KITTITAS COUNTY

DEPARTMENT OF PUBLIC WORKS

MEMORANDUM

TO: All Staff
FROM: Public Works Plan Review Team
DATE: March 17, 2025
SUBJECT: AU-25-00003 Merten

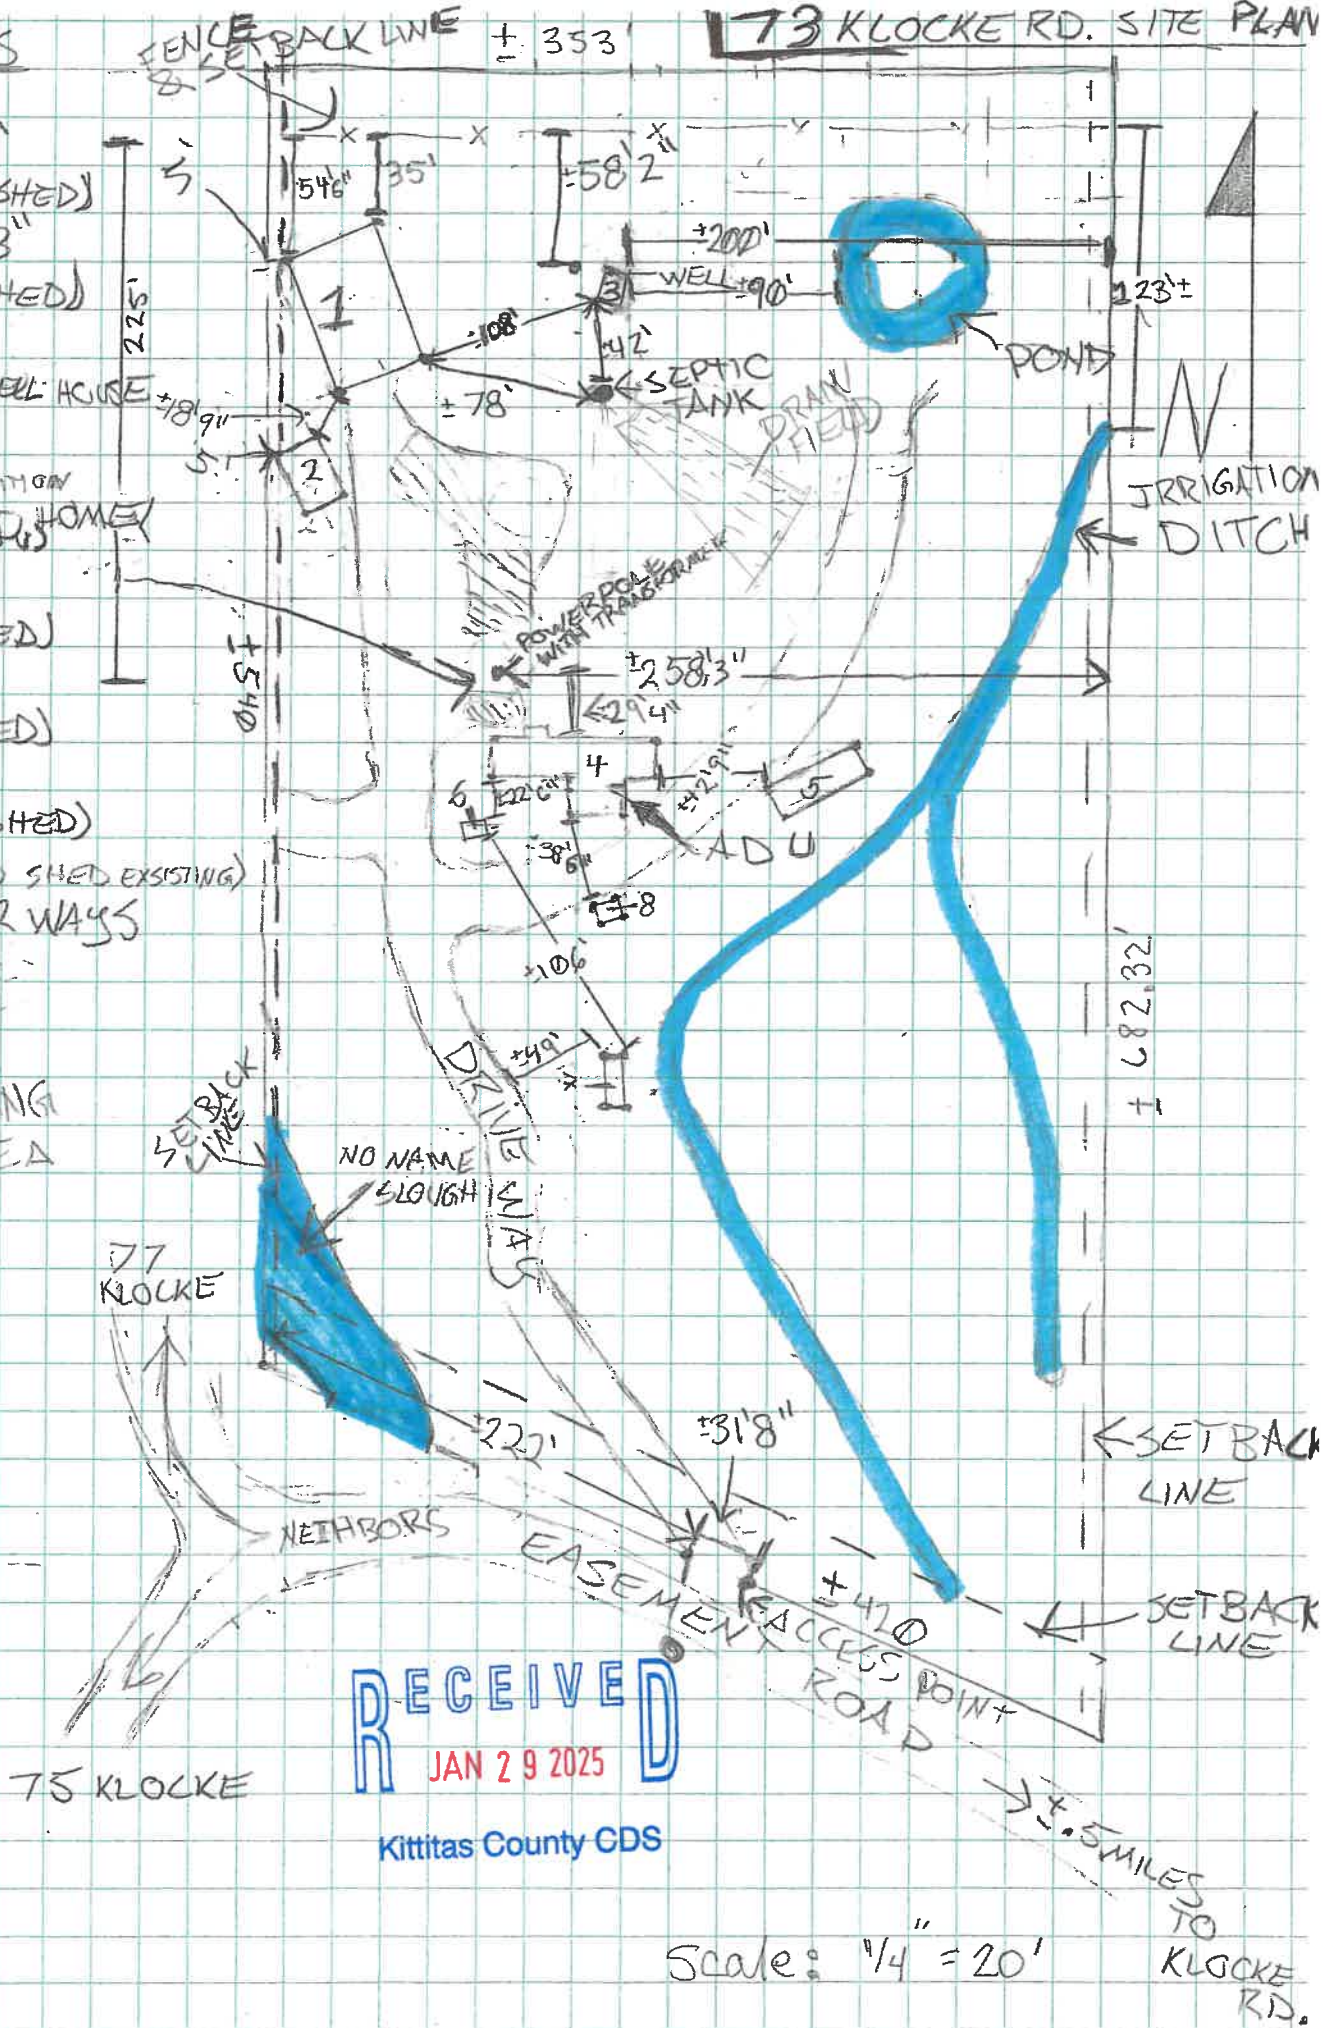
ACCESS	<ol style="list-style-type: none">1. An approved access permit shall be required from the Kittitas County Department of Public Works prior to creating any new driveway access or altering an existing access.2. Access easement is recorded under document 199803230031 for ingress and egress.3. Maintenance of driveway approaches shall be the responsibility of the owner whose property they serve. The County will not maintain accesses.4. Any further subdivision or lots to be served by proposed access may result in further access requirements. See Kittitas County Road Standards.5. In addition to the above-mentioned conditions, all applicable Kittitas County Road Standards apply to this proposal. Access is not guaranteed to any existing or created parcel on this application. (JS)
ENGINEERING	Except as exempted in KCC 14.05.060, no grading or filling upon a site involving more than one hundred (100) cubic yards shall be performed without a grading permit from the County Engineer or Public Works designee (KCC 14.05.050). An application for grading in excess of five hundred (500) cubic yards shall be accompanied by an engineered grading plan (KCC 14.05.080). (CP)

WATER MITIGATION/ METERING	Per KCC 13.35.027 water mitigation and metering will be required for the ADU because it is a new use of ground water. Parcel # 239433 is located within the OTC service area for the Kittitas County Water Bank. Please call the Kittitas County Public Works Water Resources program at (509)962-7523 to discuss mitigation options and metering requirements. (SC)
AIRPORT	No comments. (JS)

# AU-25-00003 Merten Critical Areas

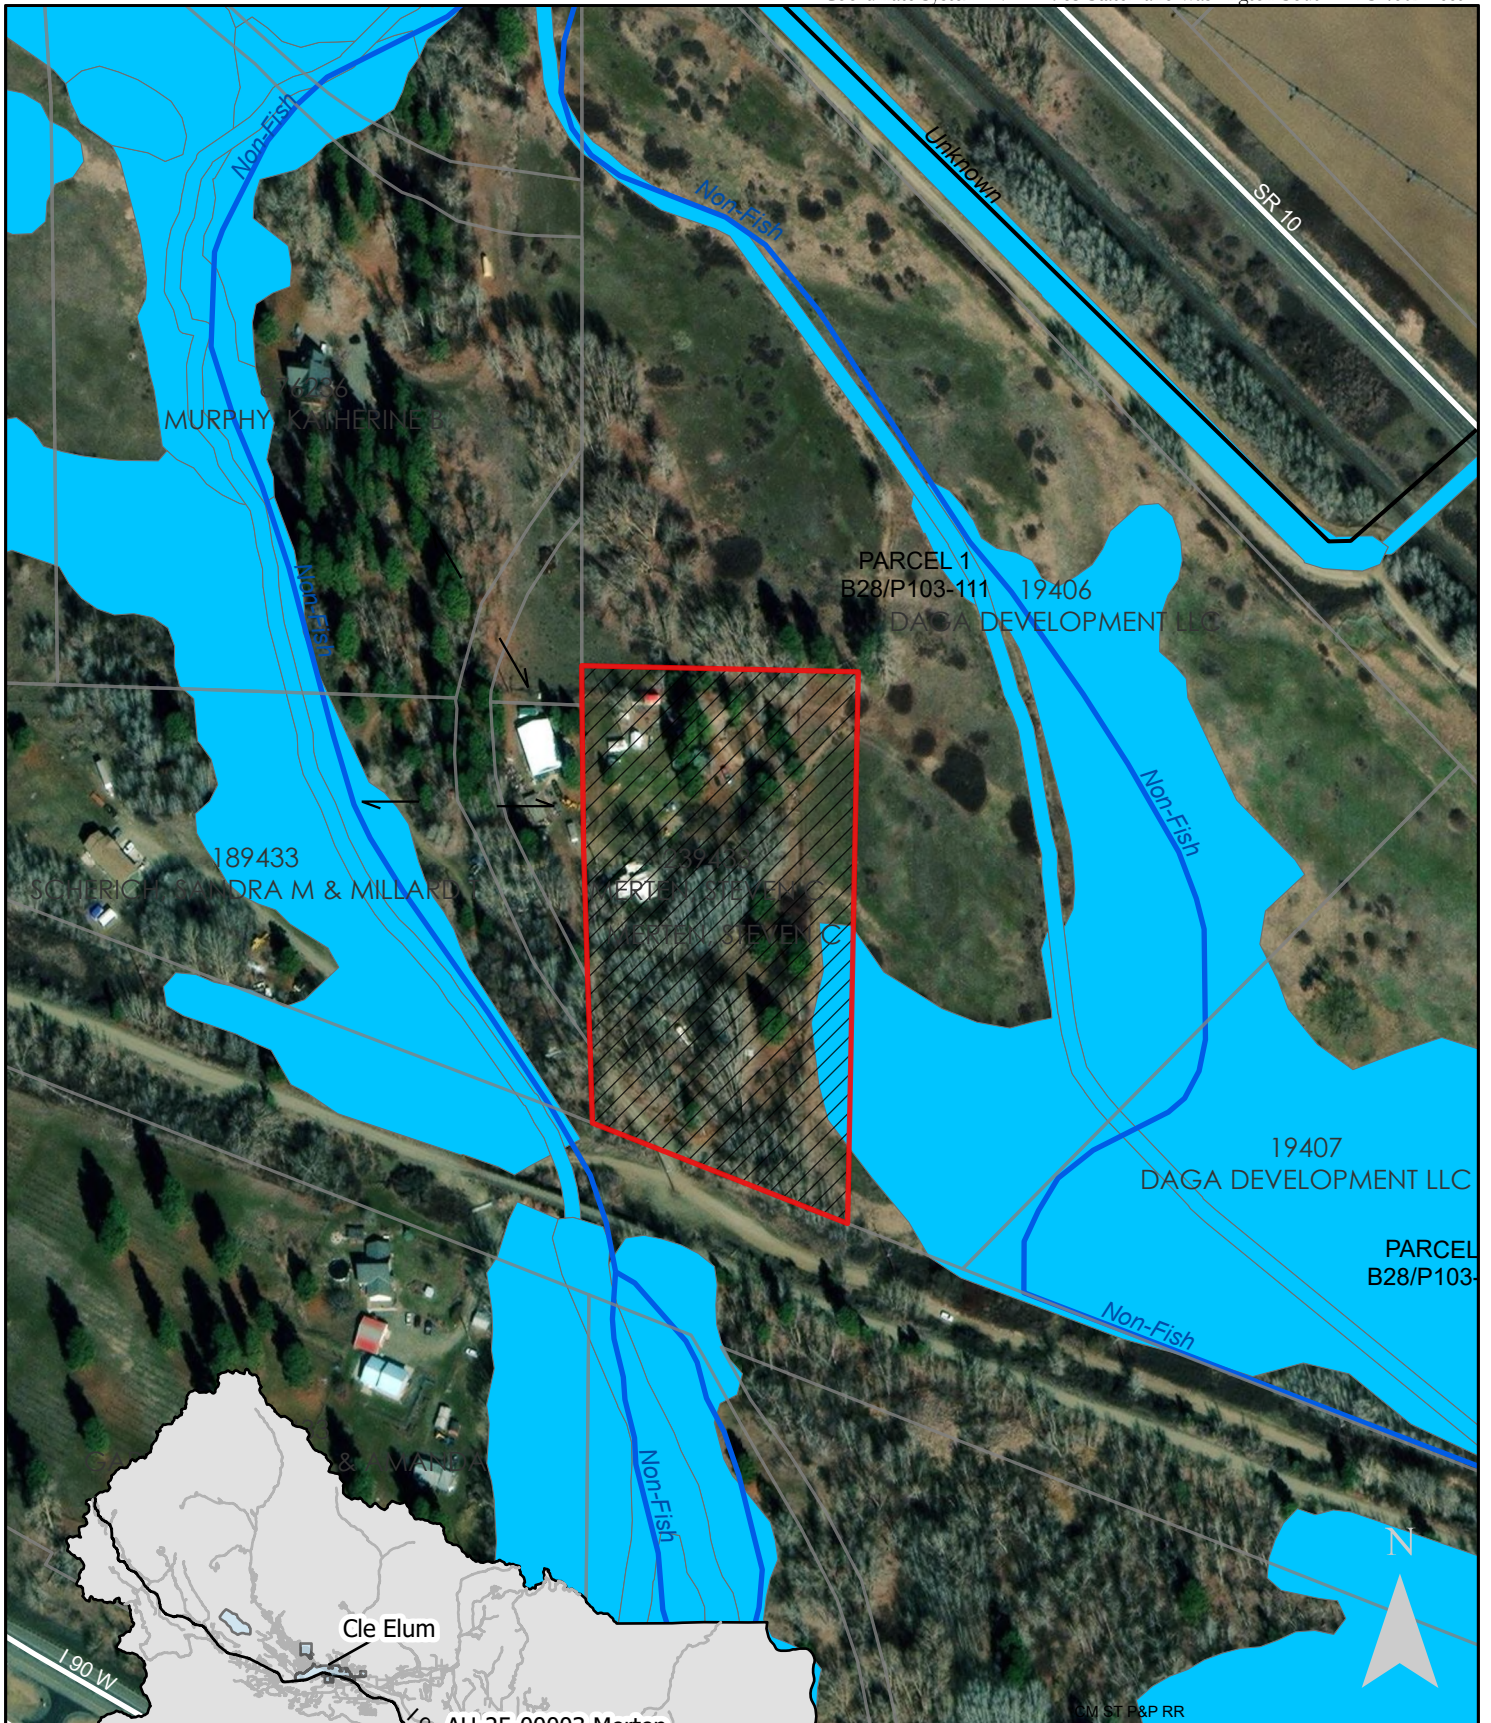
SURVEY	There are no survey comments regarding this application. (JT)
TRANSPORTATION CONCURRENCY	No transportation concurrency requirement for this project. (KAH)
FLOOD	The proposed ADU is located within the FEMA identified special flood hazard area (100-year floodplain). All activities within the floodplain require a floodplain development permit. All construction, including structures that are exempt from a building permit, must follow the guidelines within KCC 14.08. Structures may be subject to mandatory flood insurance purchase requirements. (SC)
